Our Ref: BE/121/25/DOC

Approval of details reserved by condition imposed under reference BE/176/21/PL relating to condition 26 - as-built drawings of surface water drainage scheme (see BE/120/25/DOC for condition 21 - cycle parking spaces).

The Cottage Shripney Road Bognor Regis PO22 9PA

Arun District Council have decided to **REFUSE details reserved by condition for the following reasons:**

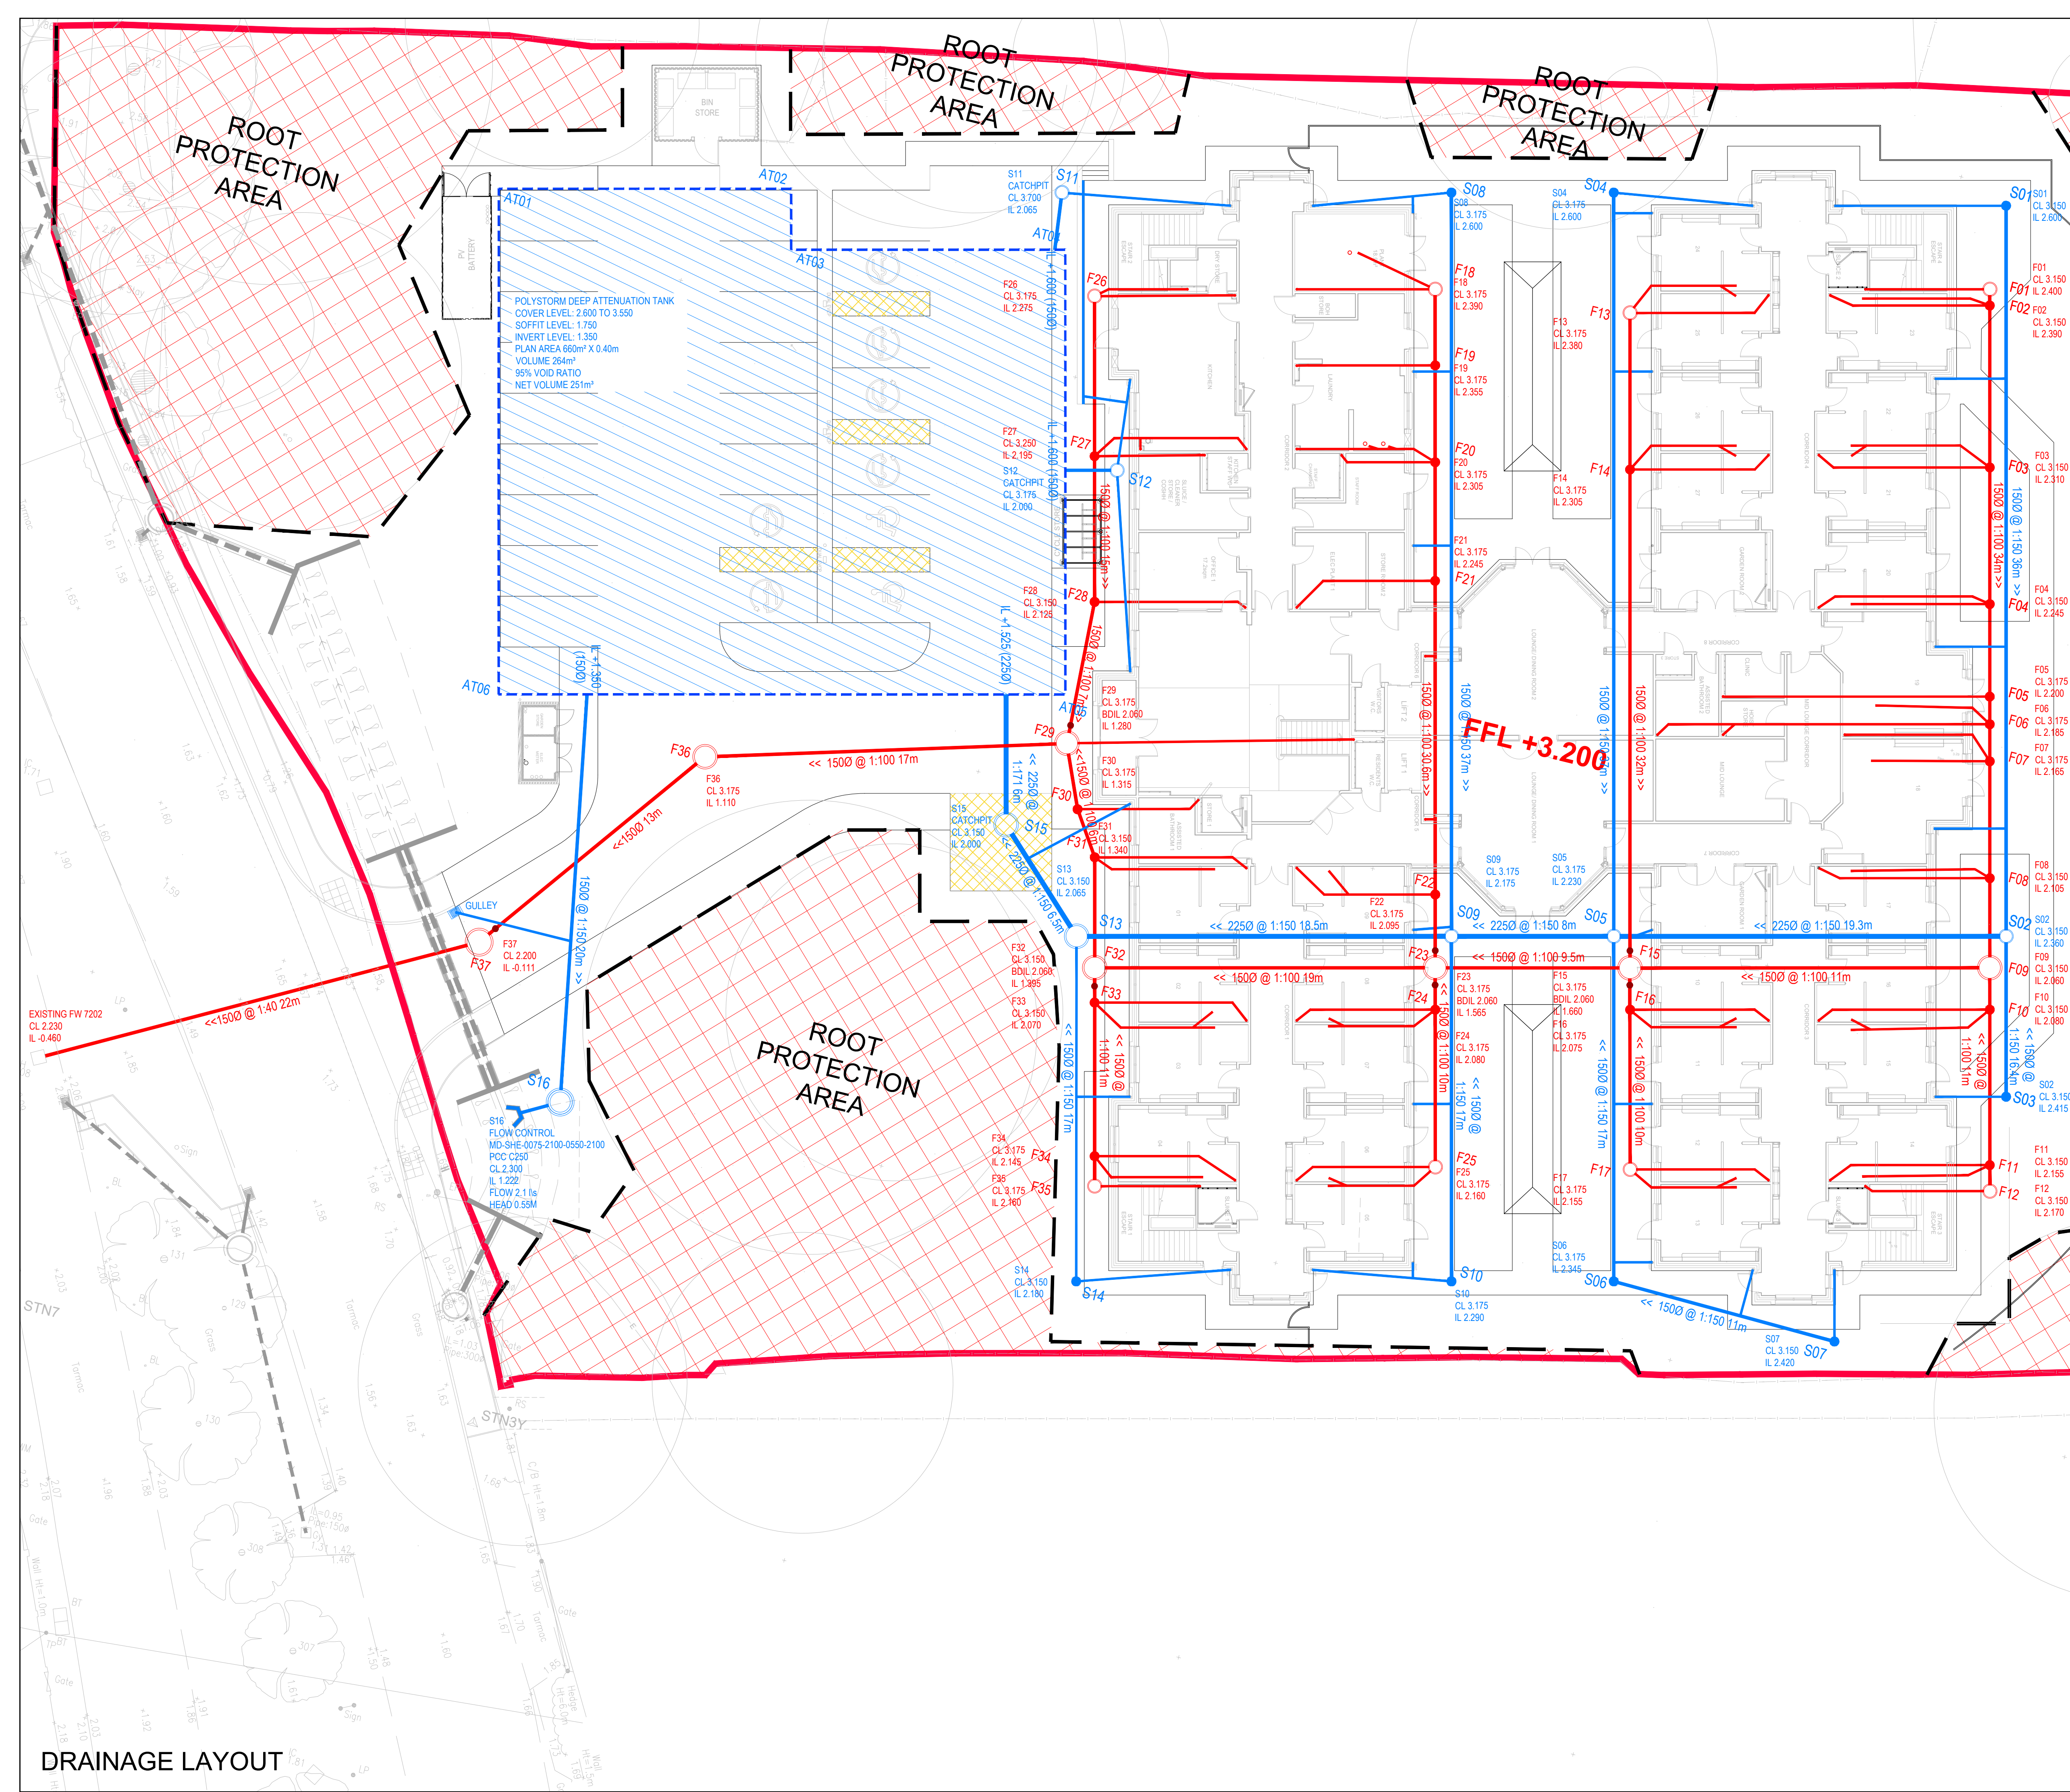
The application contained insufficient information to determine whether the drainage scheme has been built in accordance with the approved scheme.

The area, depth and volume together with the product type of the attenuation tank should be evidenced. The flow control device product and completed installation should be evidenced. The completed culverted section of the watercourse and drainage outlet should be evidenced. A report should be provided by an independent engineer with supporting evidence which confirms that the scheme was built in accordance with the approved drawings and is fit for purpose.
